BCA ASSESSMENT REPORT

Building 2A, Oakdale West Estate, Kemps Creek

**Prepared For:
Goodman Property Services (Aust) Pty Ltd**

Revision 2

1 OFFICE - GROUND FLOOR PLAN 1 : 100

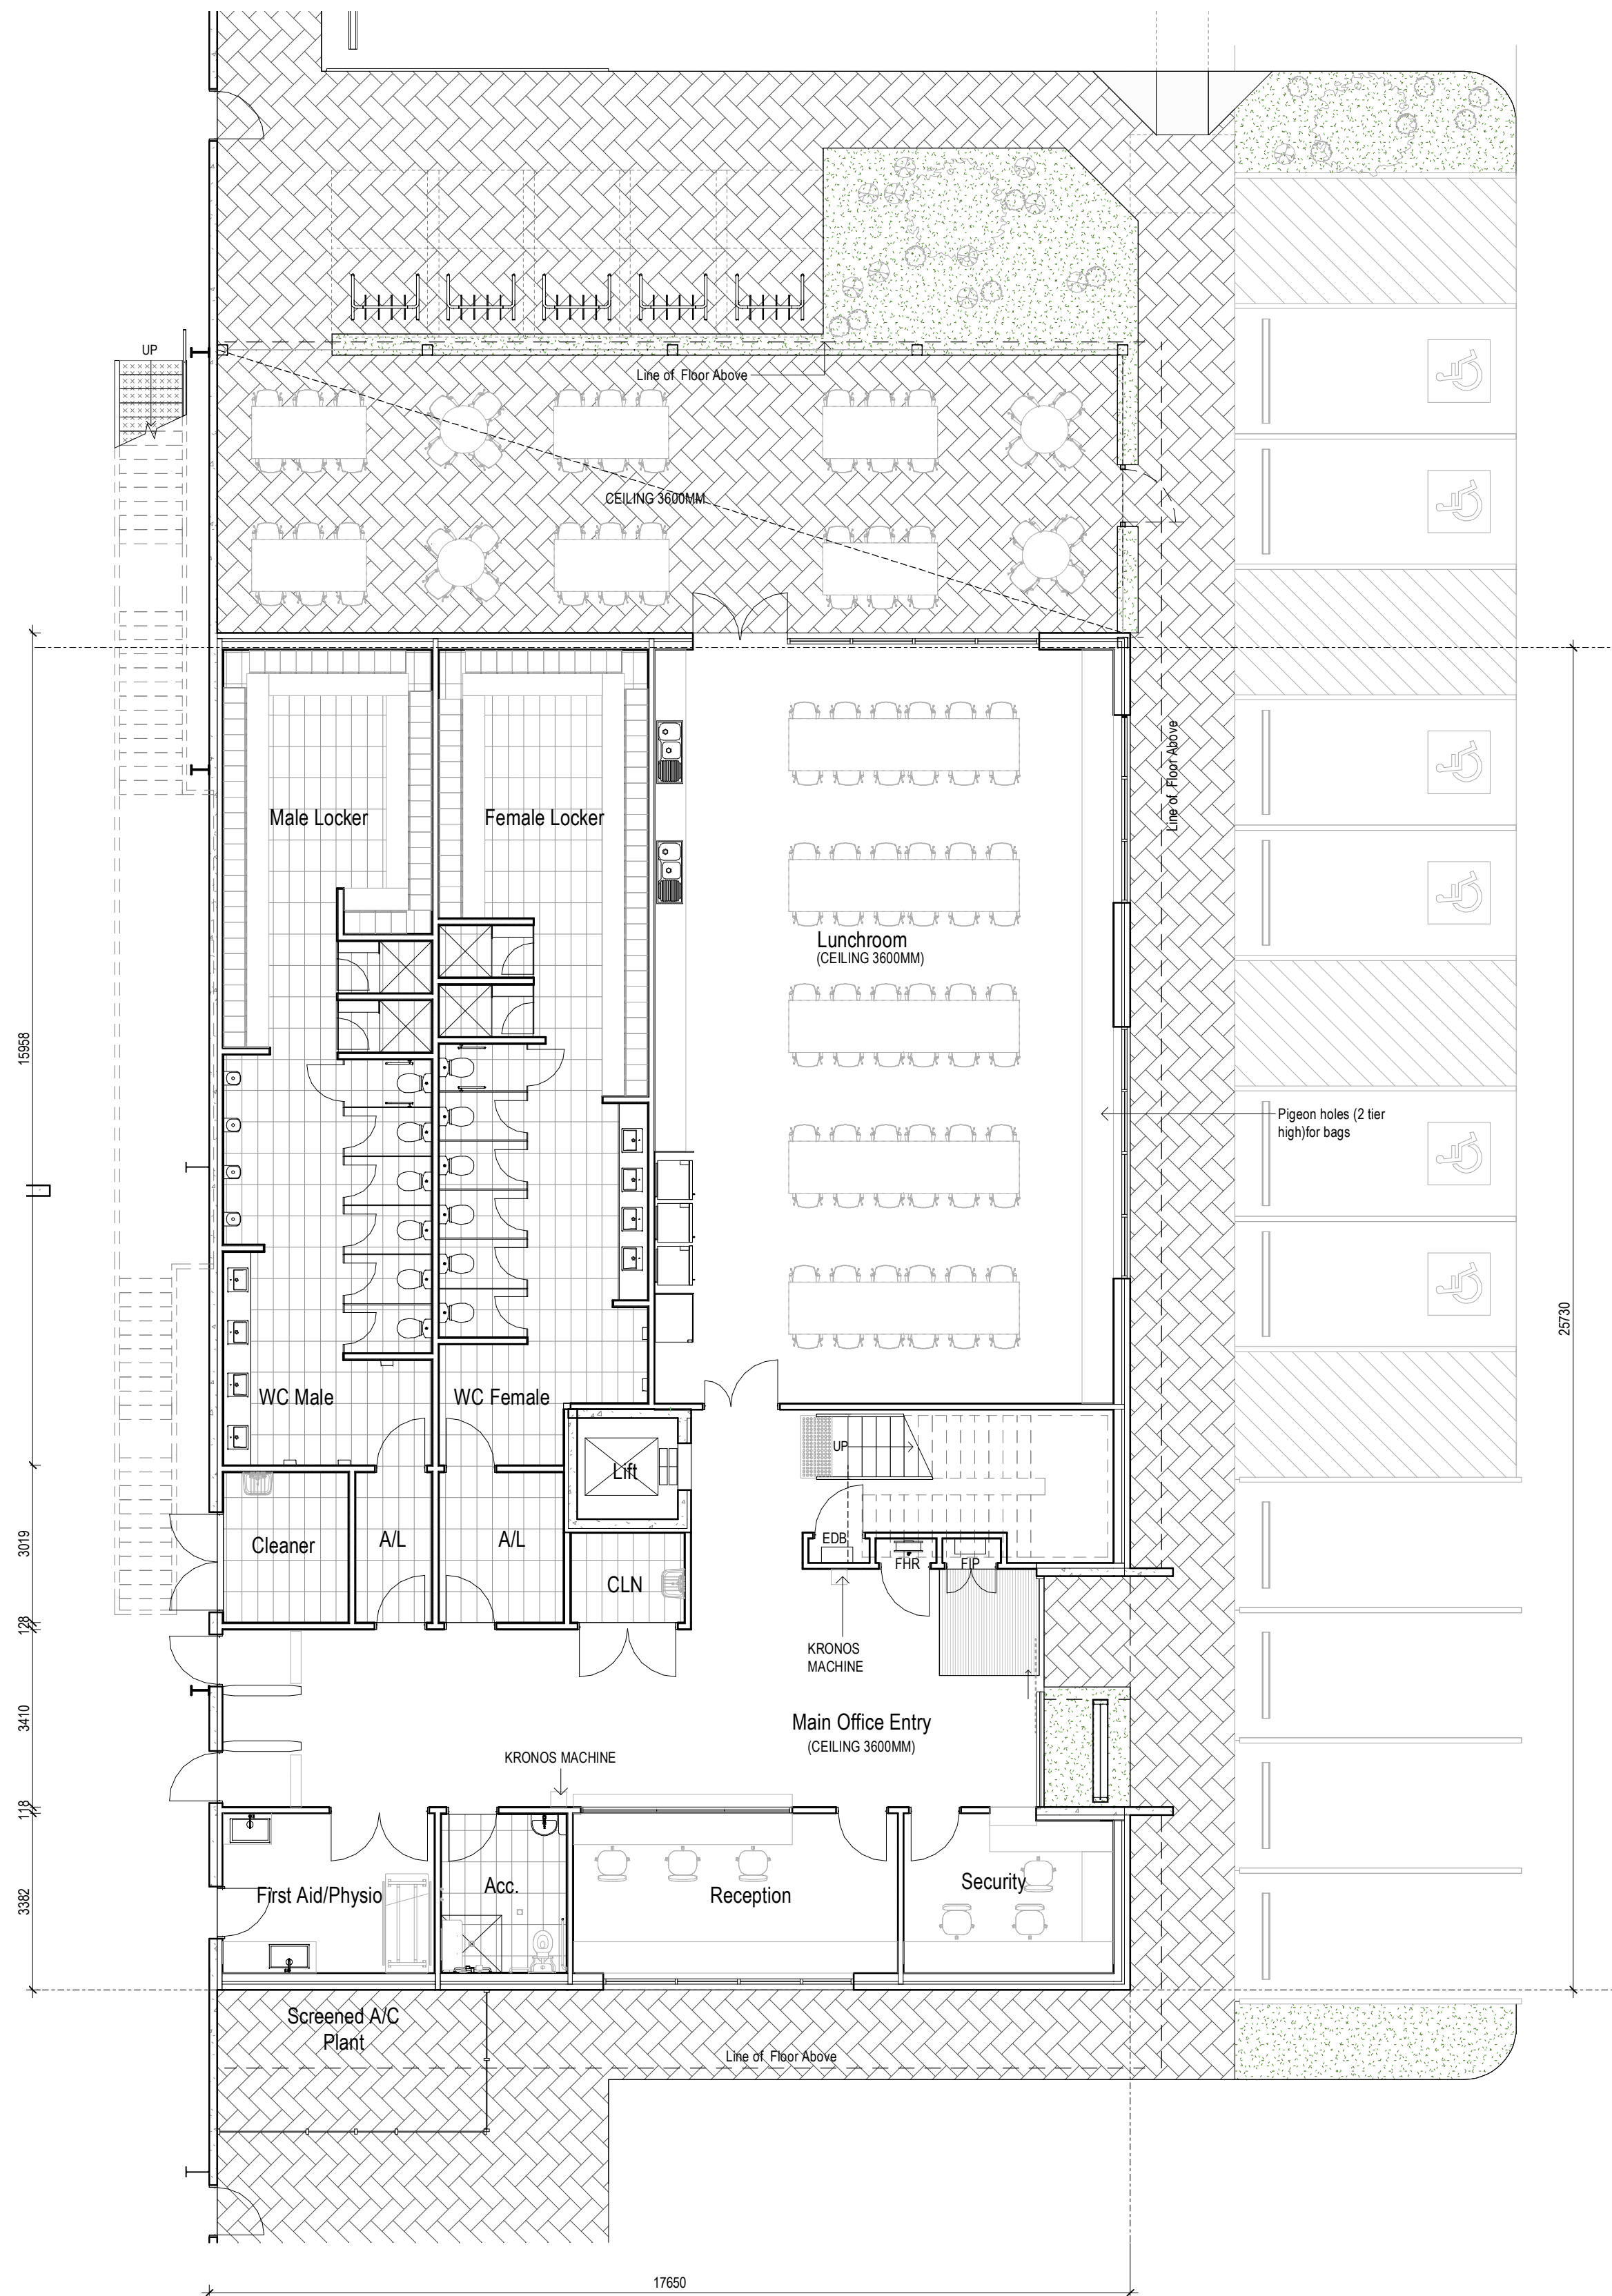
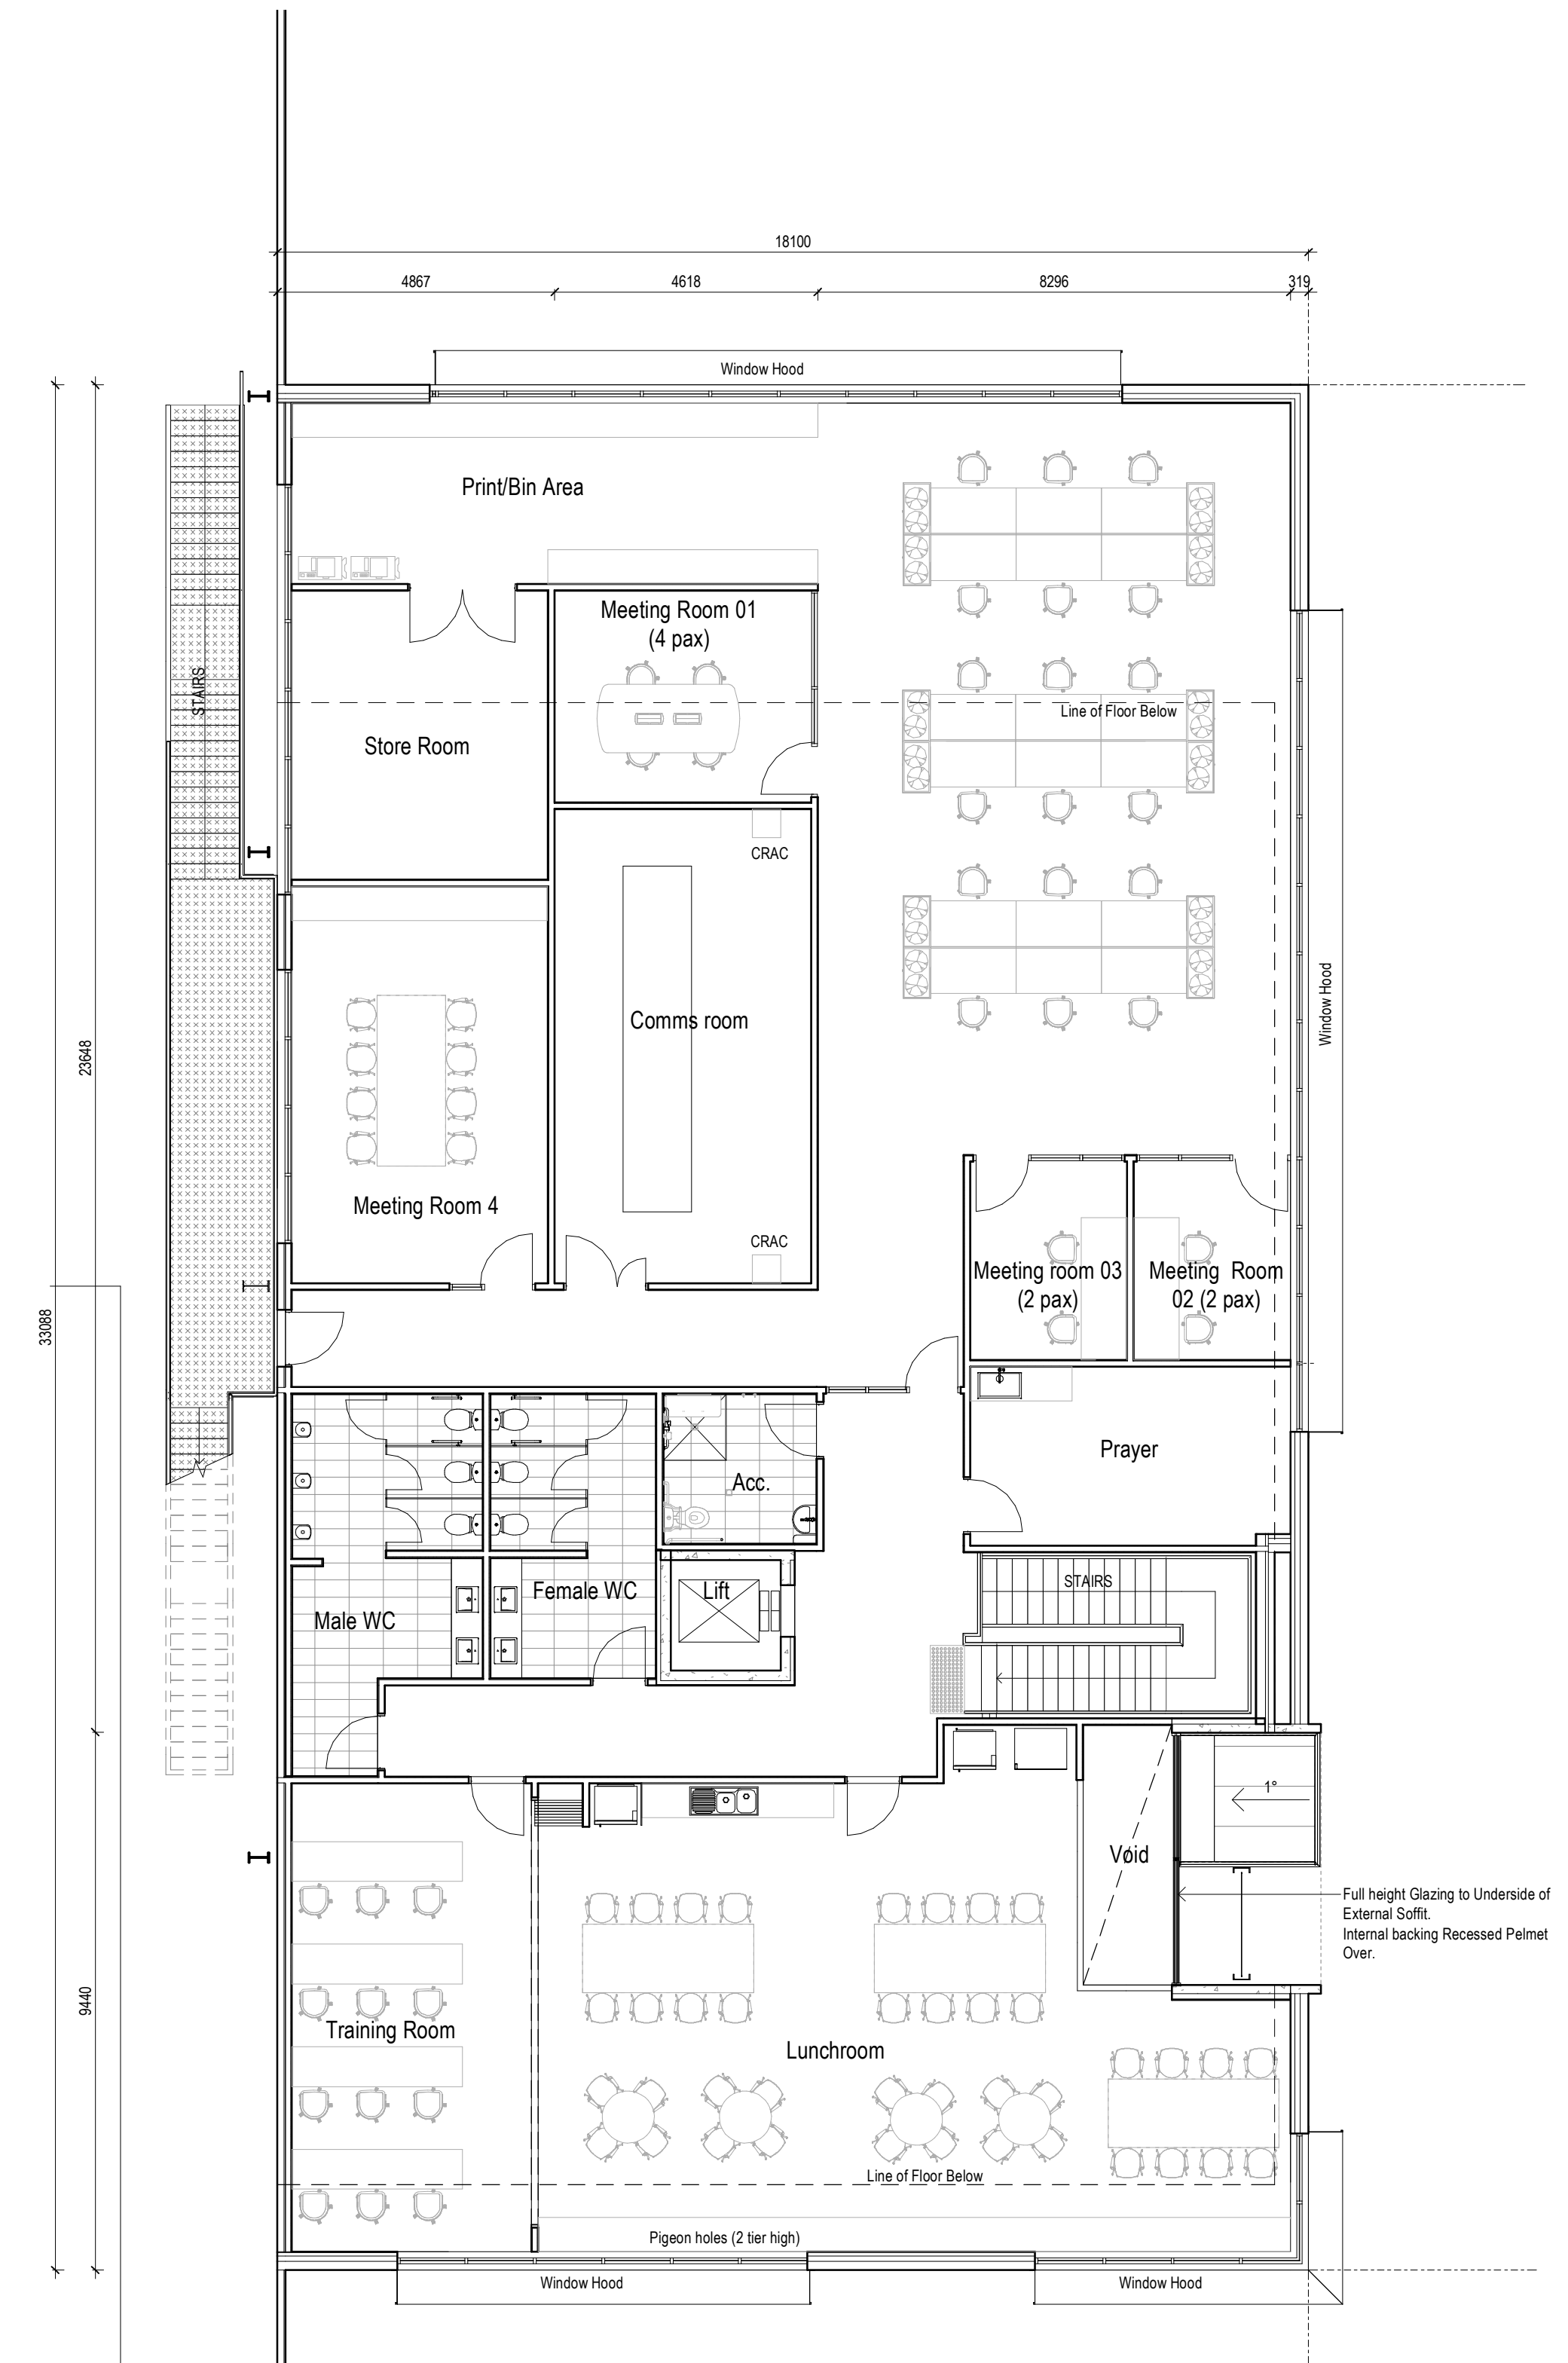
Comments: The higher FRLs of the Class 7b Warehouse areas on the Ground Floor of the Building are required to be applied to the entirety of the storey (including the main office and dock offices) unless the different classifications throughout the storey are separated by a Fire Wall that achieves an FRL of 240/240/240. Note: See comments under Spec. C1.1 below.
